From: [REDACTED]
Sent: 21 June 2017 09:25
To: Andrew Wood
Subject: Re: FG 198/16/PL - VERY URGENT

From: Andrew Wood
Sent: 21 June 2017 08:42
To: Juan Baeza
Subject: RE: FG 198/16/PL - VERY URGENT

DWG NO: P/004

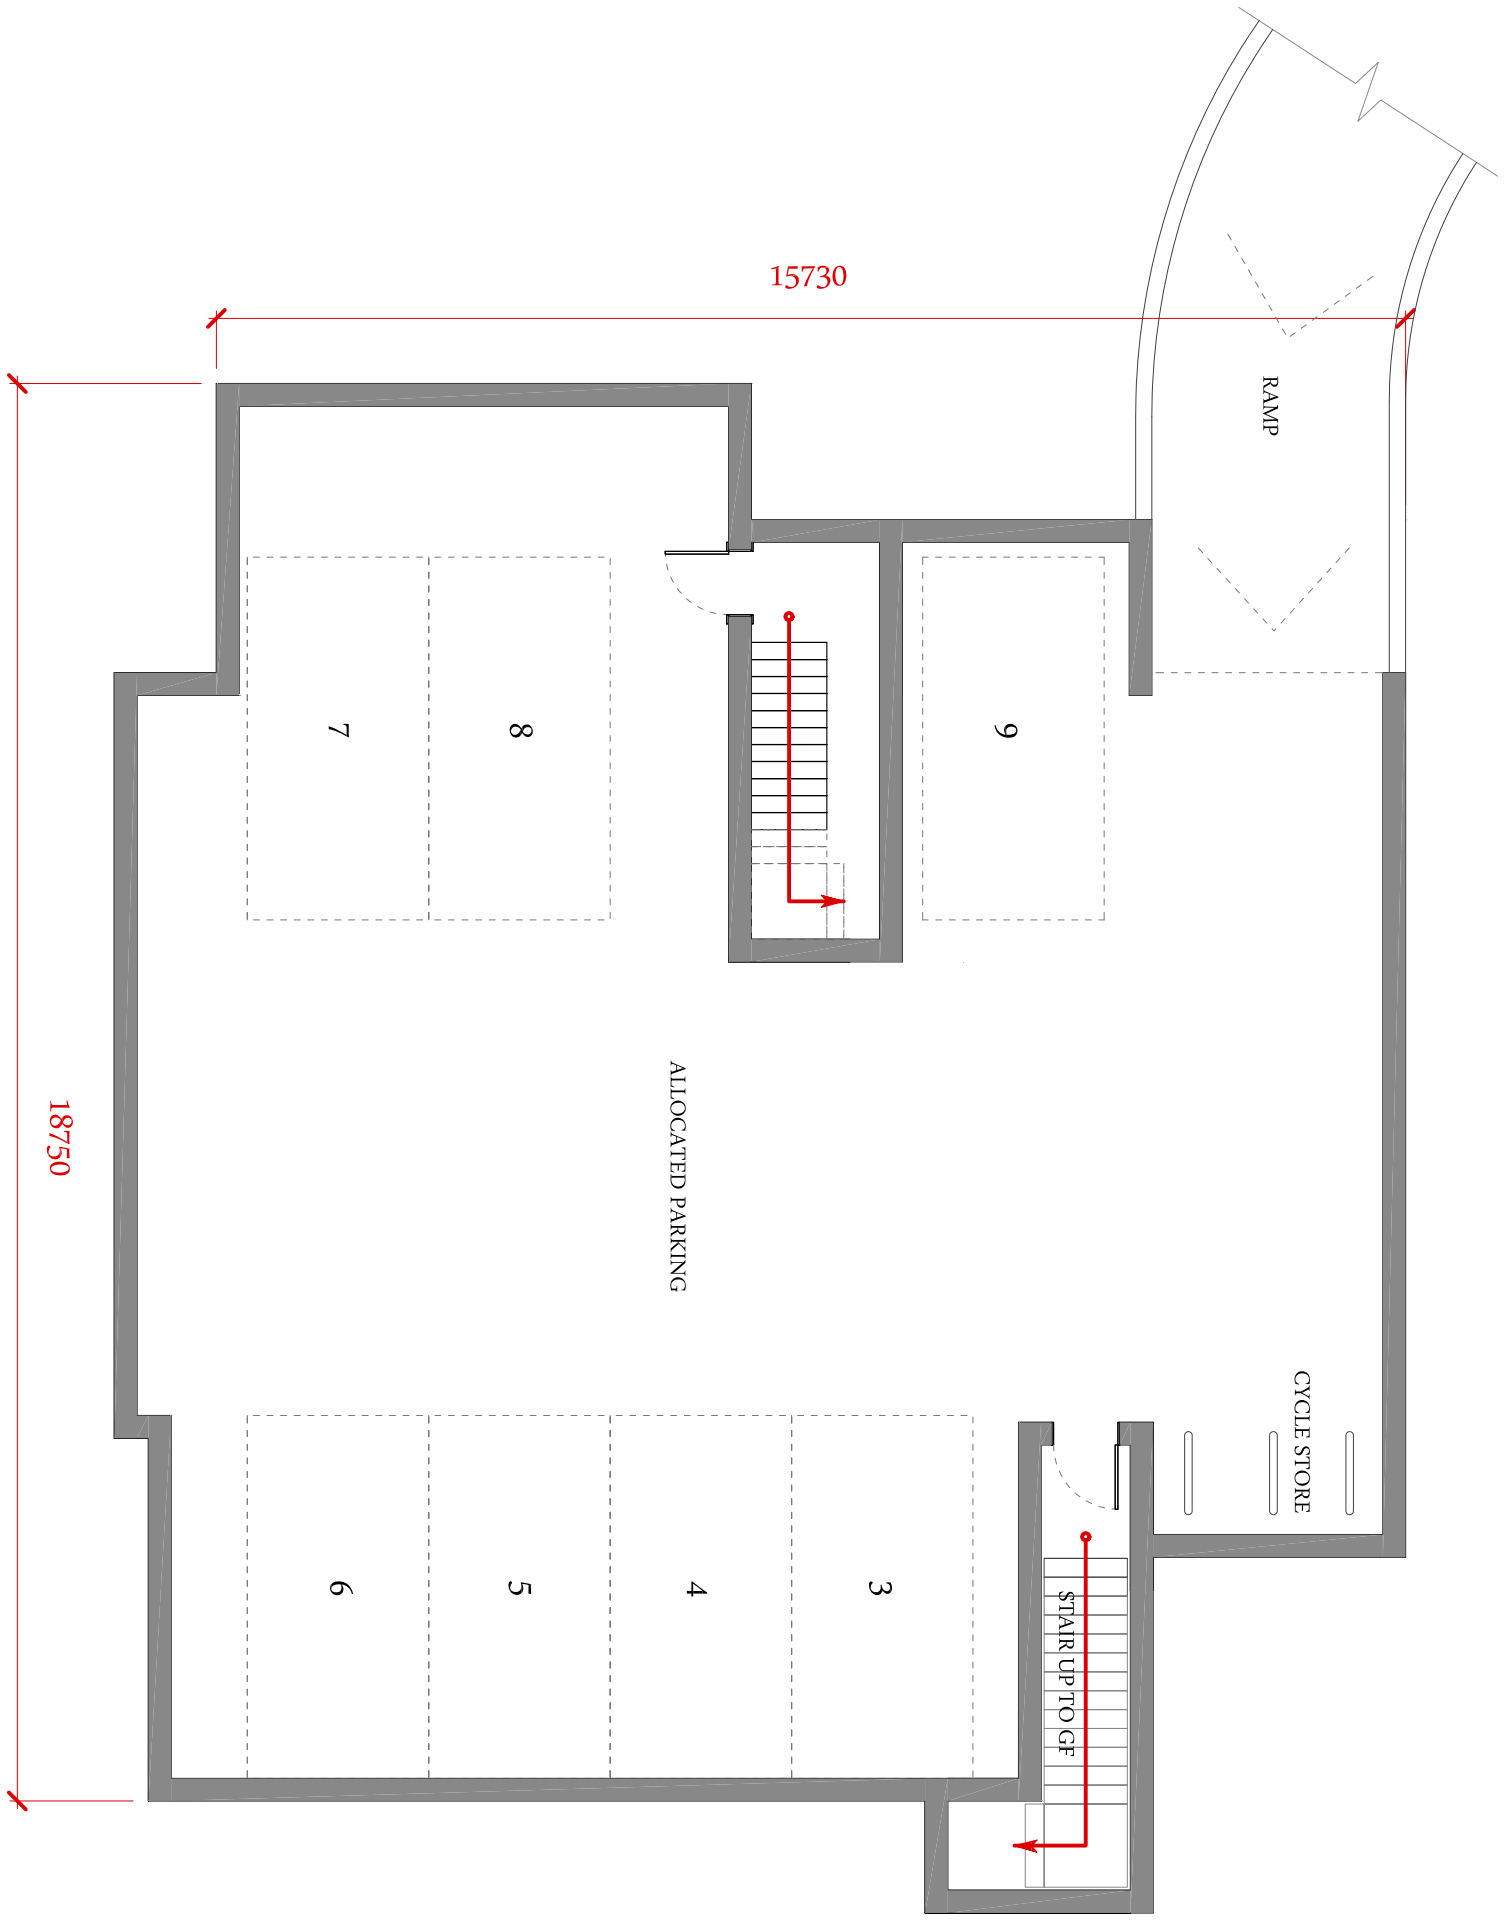
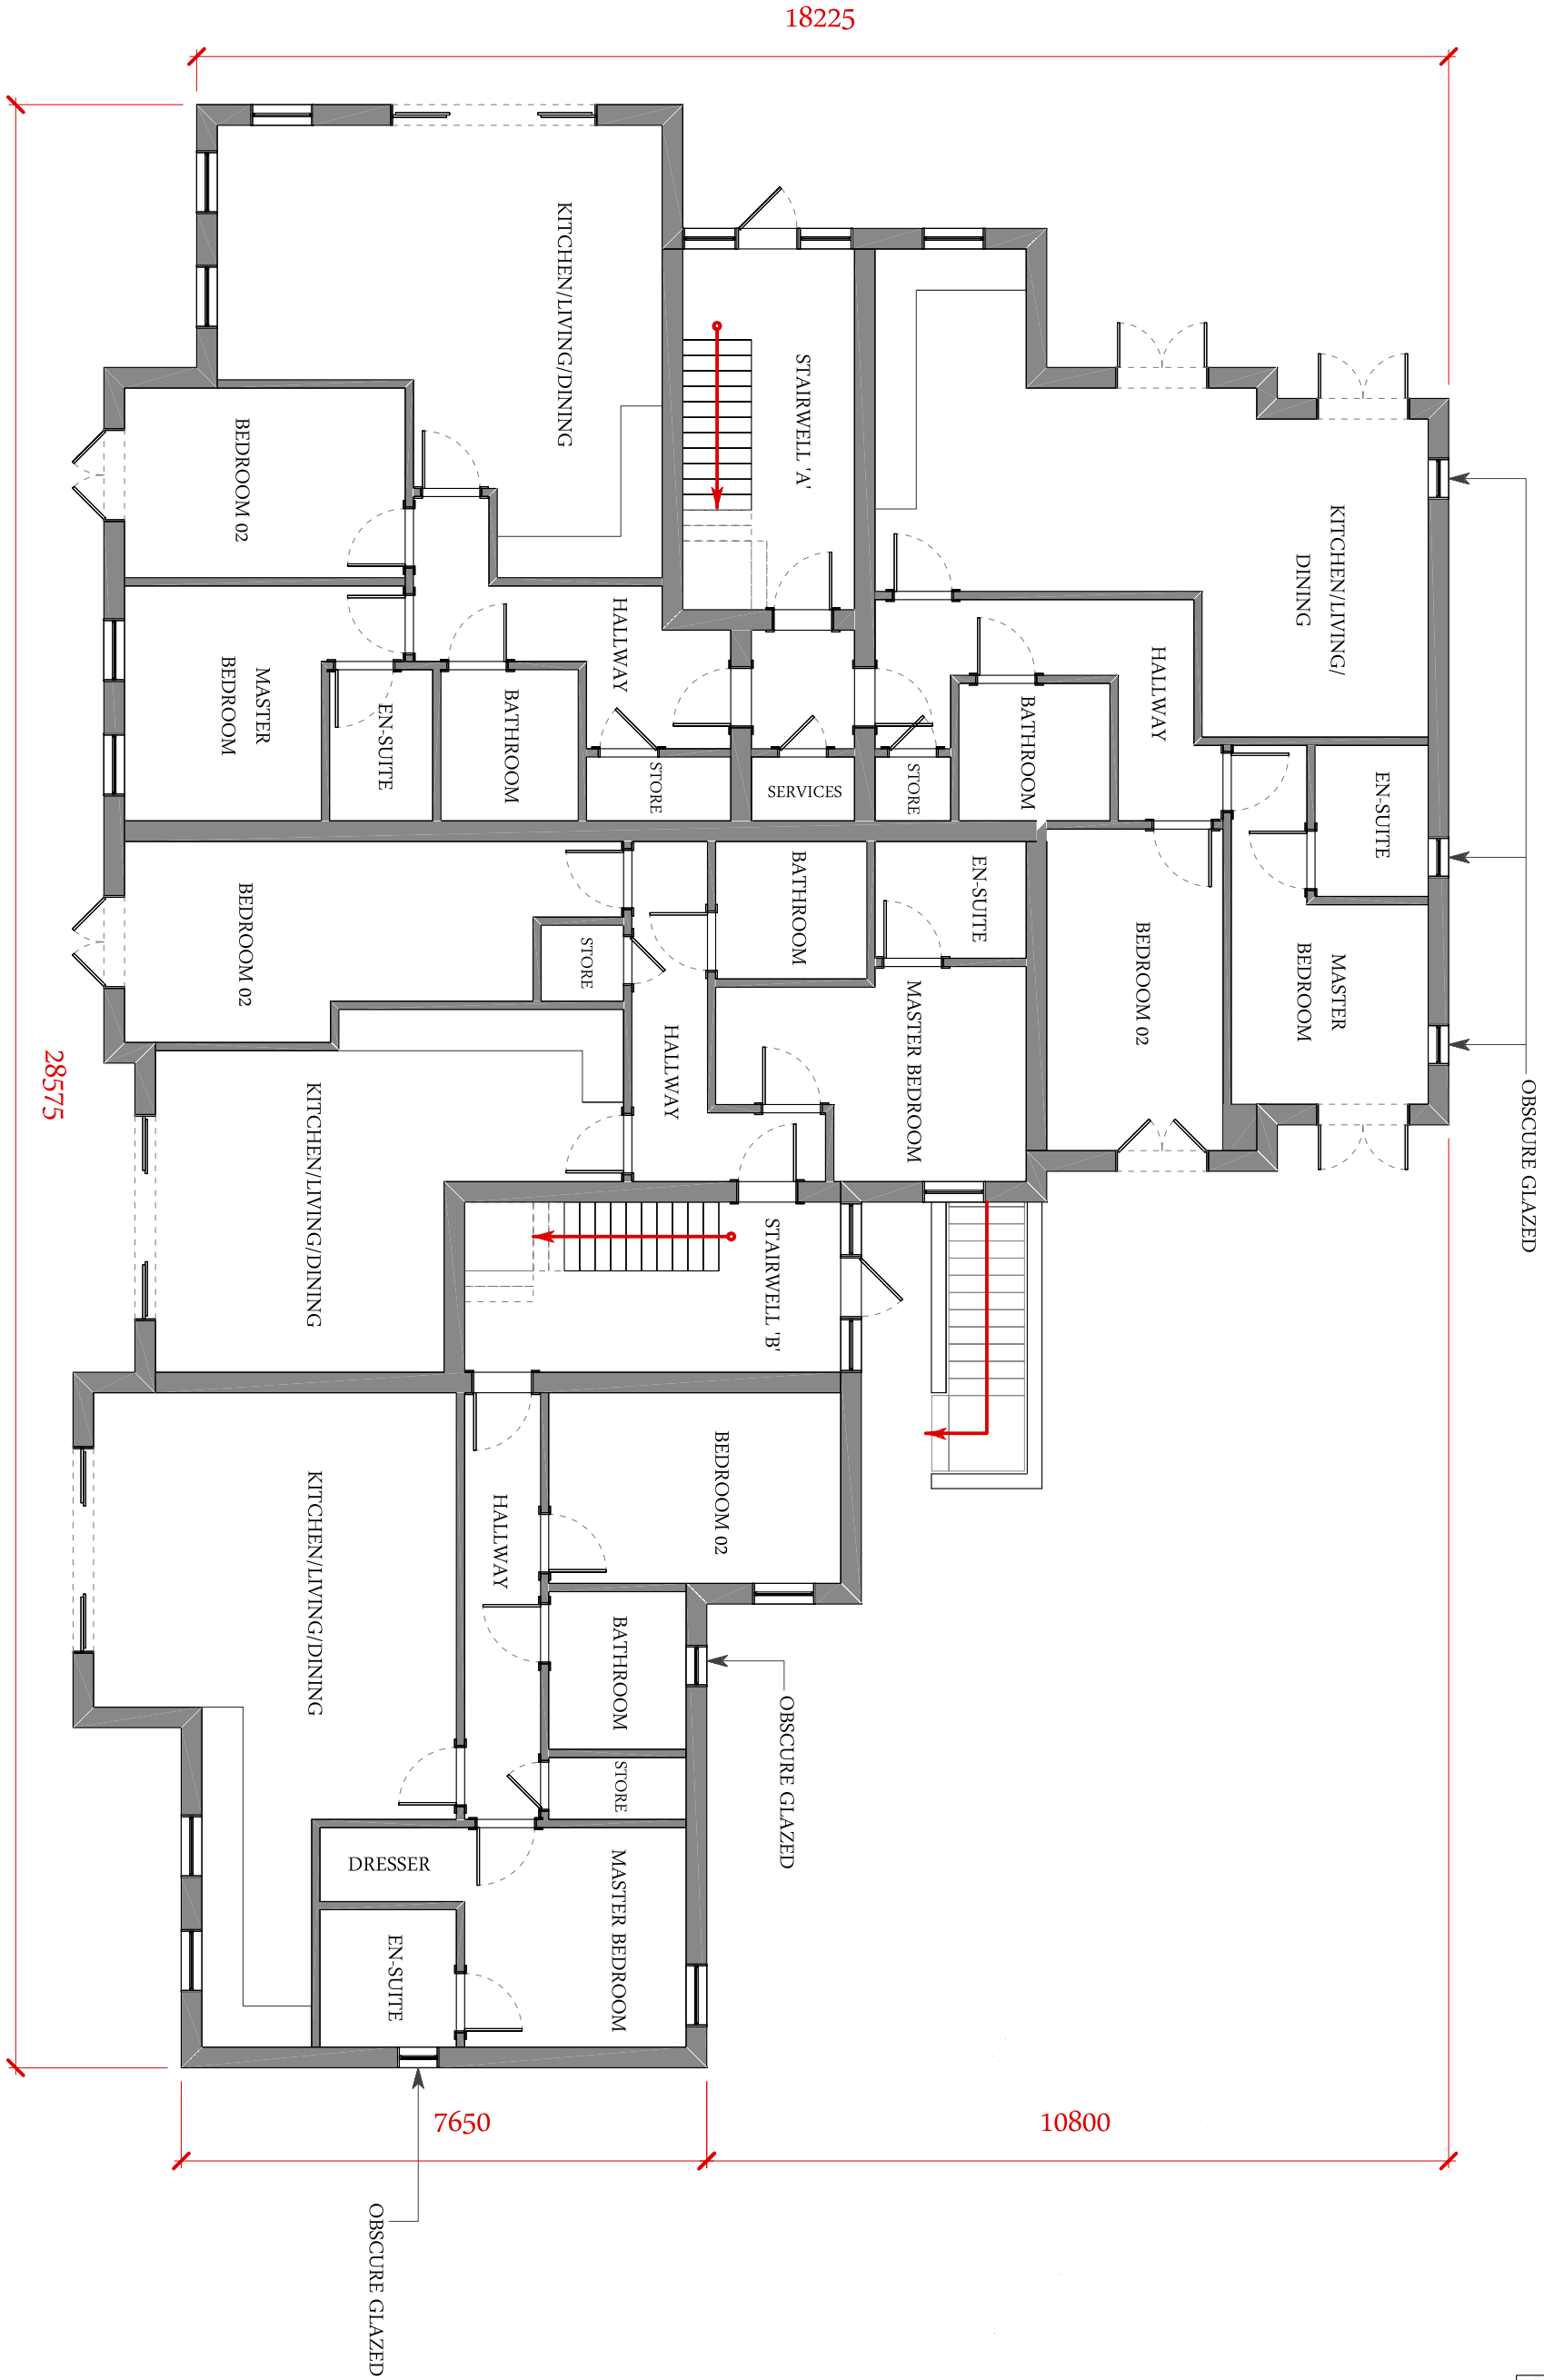
Since the ground floor windows were noted as obscure on the applicant's plans and because of the above combined with the raised ground floor height of the proposal, it is necessary to include them in the condition.

b.) Given that the report states that all windows on the West facing elevation will be obscure glazed bar the bedroom windows discussed above, why does proposed condition 14 only state that all first floor hallway, bathroom and en-suite windows at first floor level in the West and North elevations shall be obscure ? Why are the ground floor windows not included in this condition ? Why, also is the ground floor kitchen / living / dining window and the ground and first floor side windows to the master bedrooms not included in this condition ?

The Master bedroom window at first floor level was indicated to be obscure glazed on the plan PL004 Rev H however I have included it in condition 14 for the avoidance of doubt.

The ground floor windows would not overlook your property as shown in the attached photo. The sill height of windows at ground floor level would be 2.2 metres. Your garage wall along the boundary and the boundary hedge height are well in excess of this height. As a result it is not necessary to include the ground floor windows within the condition.
